**Procedural Deadline Submission**

**Response to National Highways' Response to Local Impact Reports**

The purpose of this document is to set out the joint response of North Yorkshire County Council and Richmondshire District Council (the 'Councils') to the Applicant's response to the Councils' Written Representations [REP1-040].

Drawing Title
**Land Plans
Regulation 5(2)(i)
Sheet 3 of 4**

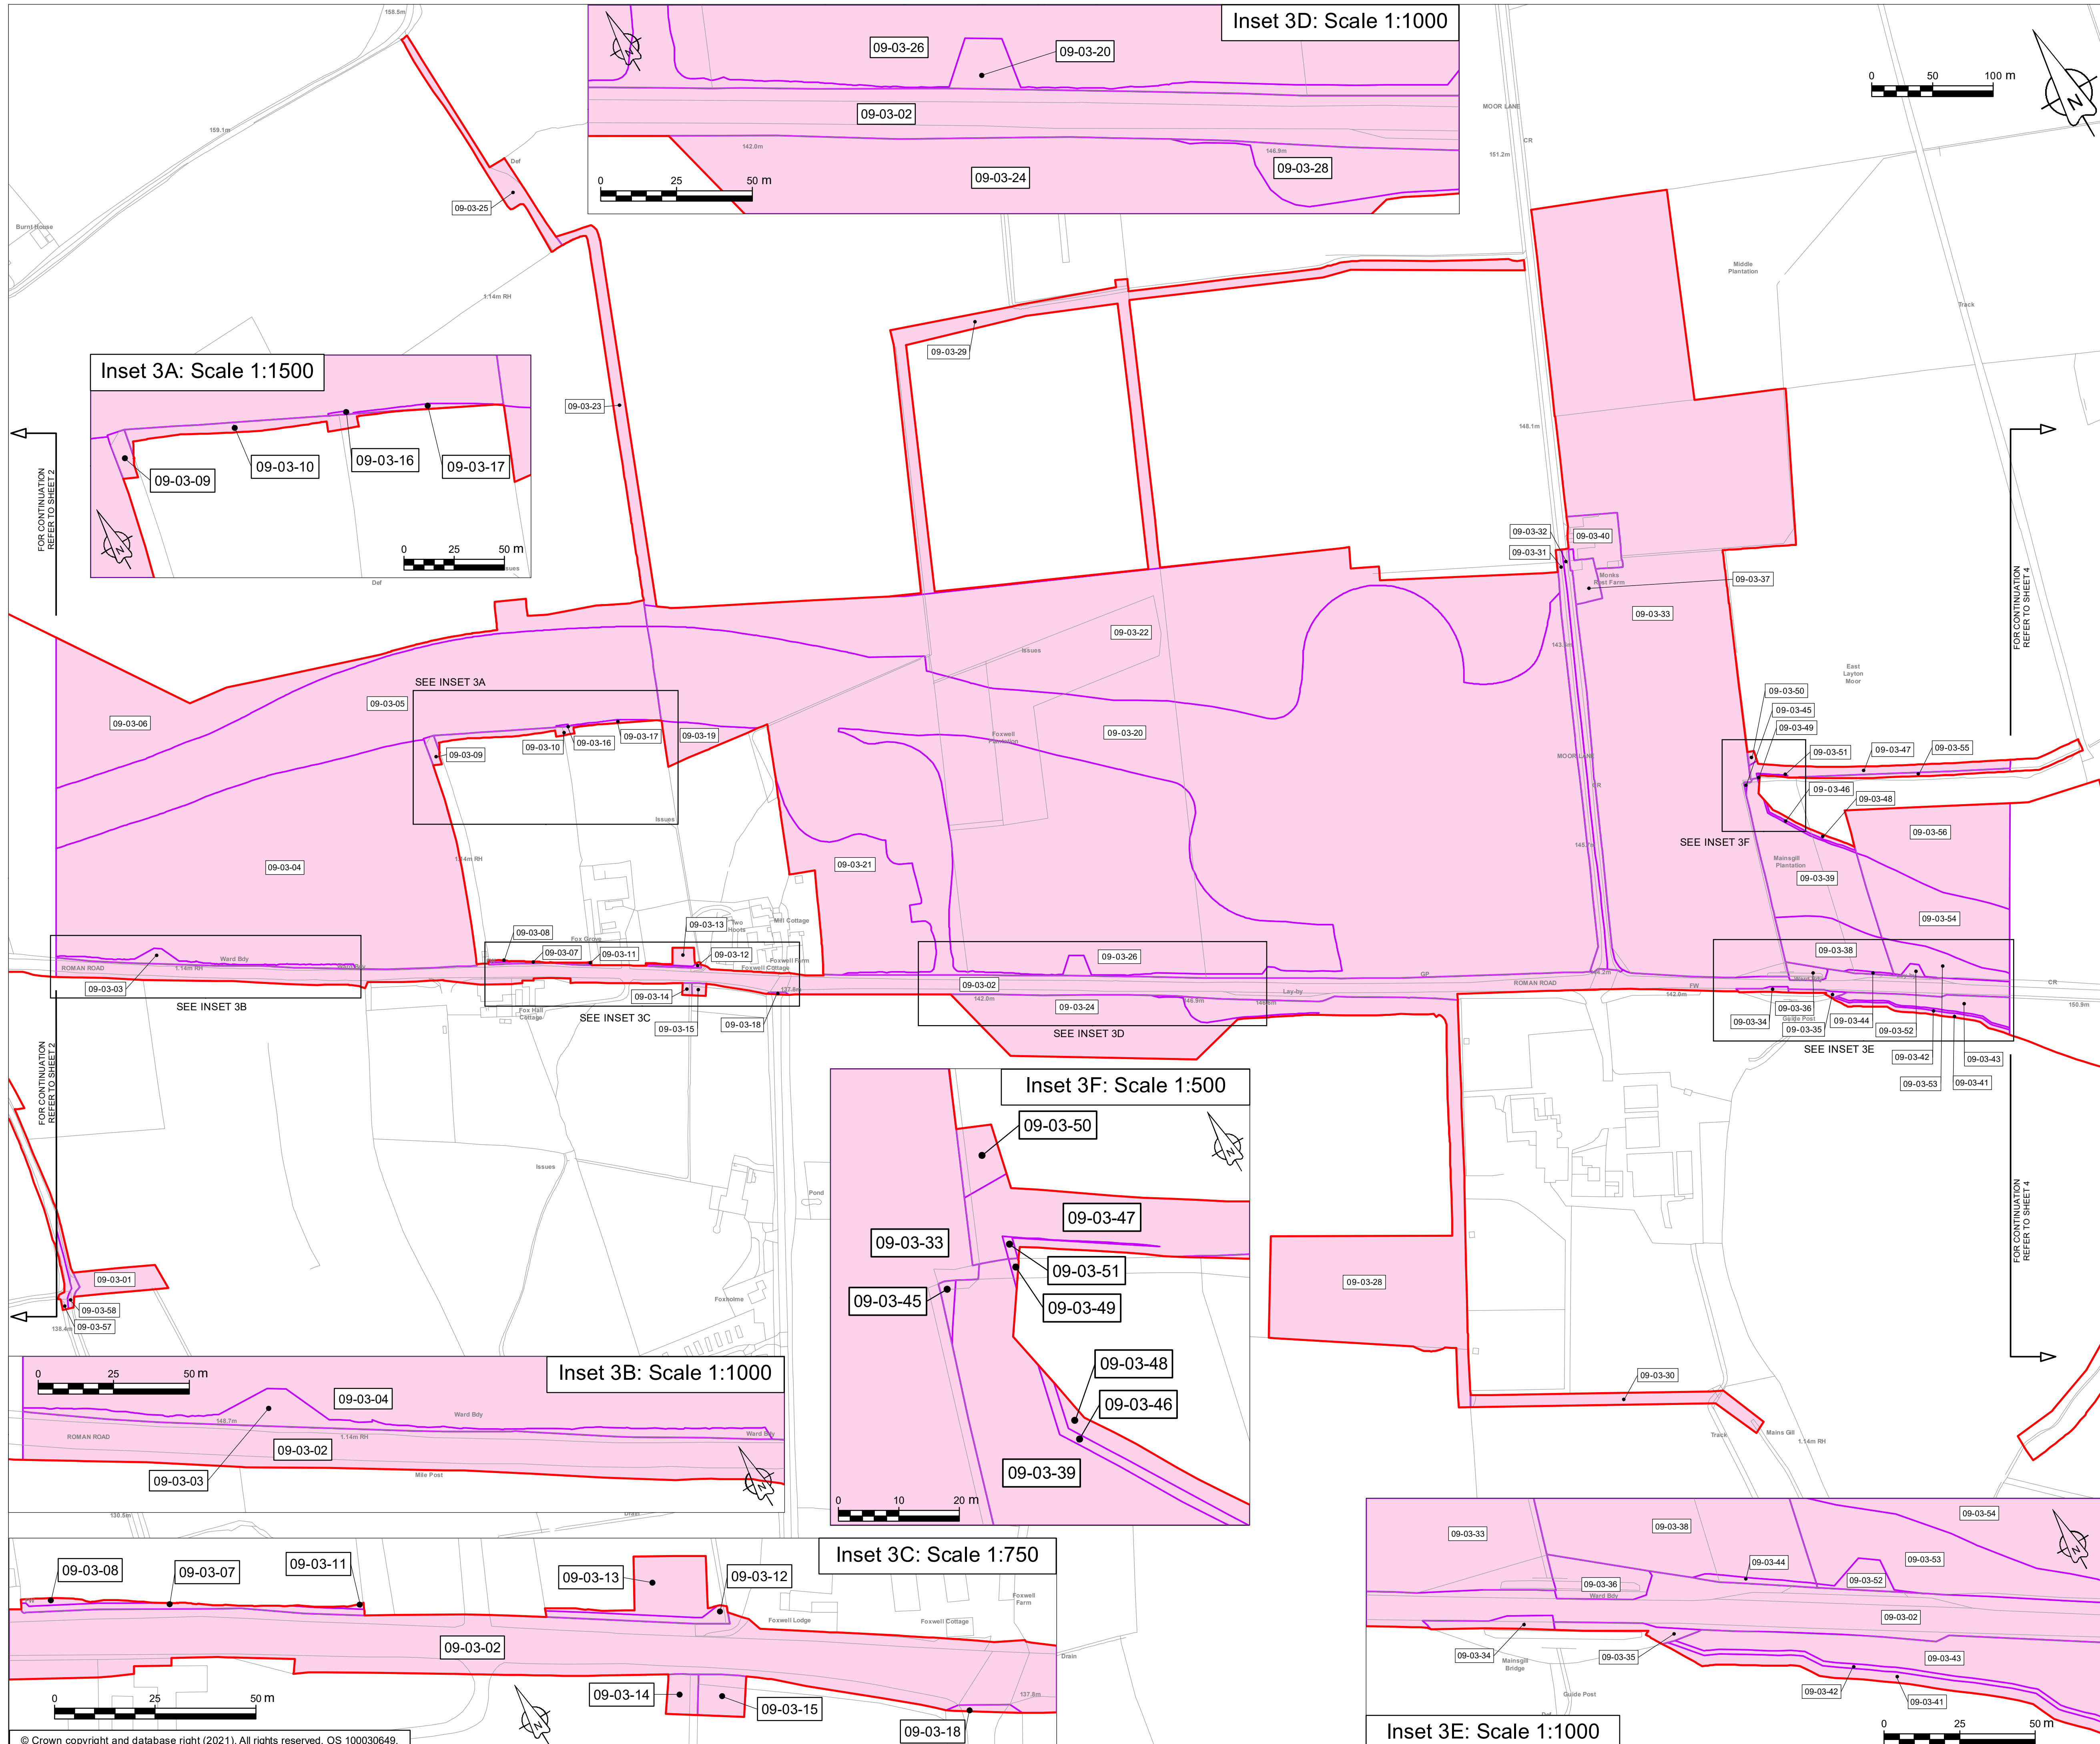
REP1-040	North Yorkshire County Council and Richmondshire District Council	Draft DCO	<p>Draft DCO errors (public rights of way)</p> <p>Scheme 09 sheet 3 Footpath 20.23/8/1 change northwards to southwards Scheme 09 sheet 4 Reference M change 46 to 82 metres</p> <p>Scheme 09 sheet 4 Reference M – junction is BW 20.33/17/1 and Warrener Lane (not A66)</p> <p>Scheme 09 sheet 4 Bridleway 20.30/8/1 Carking Moor Farm replace with Warrener House and change south-east to south</p> <p>Scheme 09 sheet 4 Reference N – junction is BW 20.33/17/1 and Warrener Lane (not A66)</p> <p>Scheme 09 sheet 4 Reference N change 180 metres to 222 metres, replace easterly with westerly</p>	<p>National Highways acknowledge the comments made on the drafting errors and can confirm the following amendments will appear in a future iteration of the Draft Development Consent Order (Document Reference 5.1, APP- 285, page 111 and 113)</p> <p>Footpath 20.23/8/1 - northwards to change to southwards Reference M – distance to be changed from 46 to 82 metres</p> <p>Reference M – description text to be updated to reference “20.33/17/1 and Warrener Lane” (not A66)</p> <p>Scheme 09 sheet 4 Bridleway 20.30/8/1 Carking Moor Farm replace with Warrener House and change south-east to south</p> <p>Reference N – description text to be updated to reference “20.33/17/1 and Warrener Lane” (not A66)</p> <p>Reference N distance to be changed from 180 metres to 222 metres.</p>		Noted
